**Consultation Response from KC,
Lead Local Flood Authority**

2021/91506 Shop Lane, Kirkheaton, Huddersfield, HD5 0DB

Reserved matters application pursuant to outline permission 2014/92535 for erection of 41 dwellings, formation of access and associated infrastructure

Date Responded: 10th July 2023

TITLE  
**PROPOSED LAND DRAINAGE SHEET 1 OF 2**

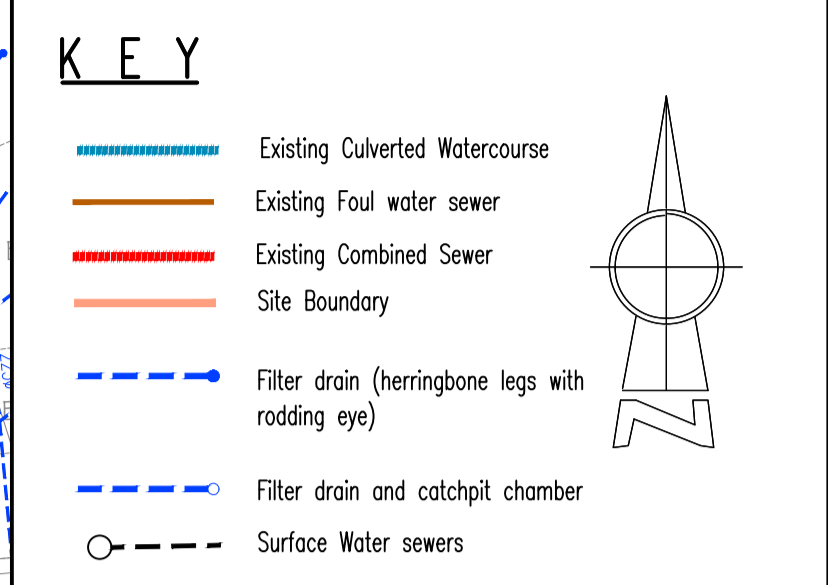
Development shall not commence until a scheme detailing the piping of the watercourses within the site, and land drainage serving this or other applications crossing areas within and between red line boundaries, as demonstrated on submitted locations plans. The scheme will include a detailed maintenance and management regime (itinerary and schedule) for the piped watercourse and piped land drainage for the lifetime of the site and attached to a unilateral undertaking under section 106 of the Town and Country Planning Act 1990, to create a management company to carry out the maintenance regime. The scheme shall be submitted to and approved in writing by the Local Planning Authority. No part of the

Alongside planning application 2021/92527 for Cockley Hill Lane, that shares the drainage outfall, we expect finalised plans to ensure at least one road gully on Shop Lane is connected to the existing trough so that some flow is maintained along this route. This should be included in the detailed design for discharge of conditions applications for any outline and reserved matters applications.
